Transport
Roads & Maritime
Services

CE12/0536
NWRL EIS1

MP 06_0157 NORTH WEST RAIL LINK (NWRL) – STAGED STATE SIGNIFICANT INFRASTRUCTURE MODIFICATION AND STATE SIGNIFICANT INFRASTRUCTURE APPLICATION – MAJOR CIVIL CONSTRUCTION WORKS (SSI-5100).

Figure 7.15 Cherrybrook Station Site Layout

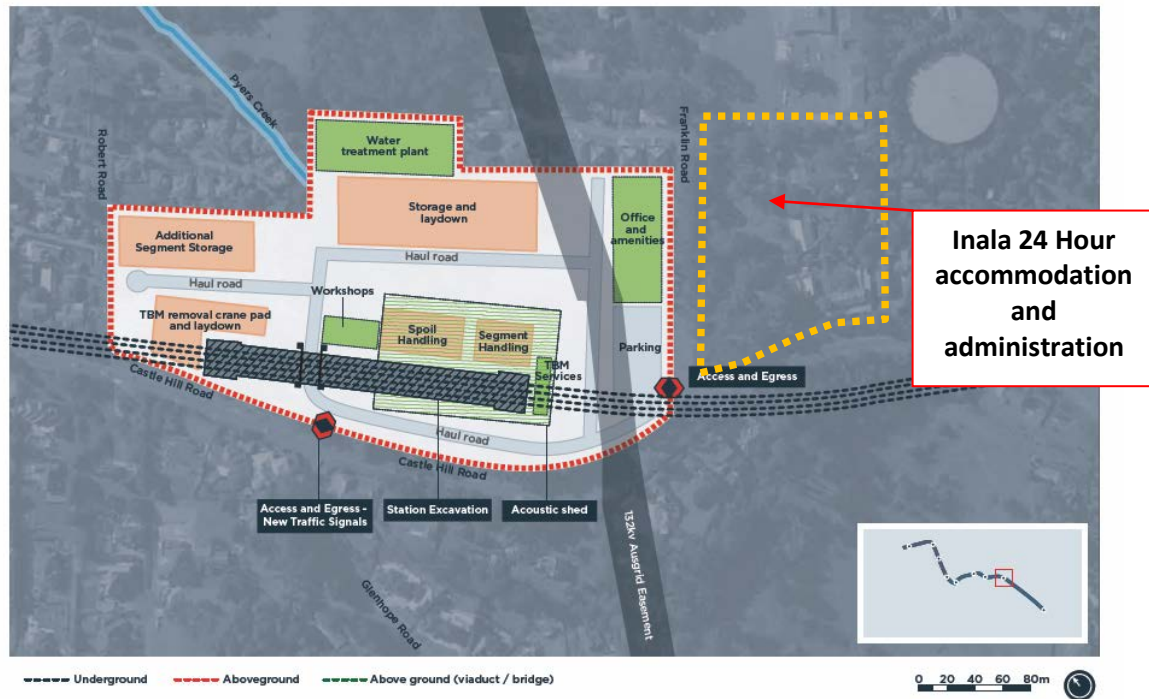
- The proposed signalisation of the intersection of Castle Hill Road/Glenhope Road must be designed to include the following:
 - The provision of a fourth leg.
 - Designed to ensure double-diamond phasing operation.
 - The provision of separate right turn bays.
 - The provision of a separate left turn lane from Castle Hill Road into Glenhope Road.
 - Pedestrian crossing facilities.

Signalisation of this intersection would be subject to provision of technical assessment against the warrants for traffic signals and the provision to a suitably designed layout and appropriate consultation with Council/affected parties.

- The proposed signalisation of the Castle Hill Road/Franklin Road intersection must be designed to include the following:

- Comply with relevant Austroads and RMS supplements sight line requirements,
- The banning of right turn movements from Castle Hill Road into Franklin Road,
- Provision of separate left and right turn approach lanes within Franklin Road,
- Separate long left turn lane from Castle Hill Road into Franklin Road,
- Appropriate pedestrian crossing facilities.

Signalisation of this intersection would be subject to the provision to a suitably designed layout and appropriate consultation with Council/affected parties.

Approval to the signalisation of the intersection will only be granted in consideration of the construction activities, RMS reserves the right to remove the proposed signals at the Castle Hill Road/Franklin Road intersection at any time after the completion of the construction of the NWRL.
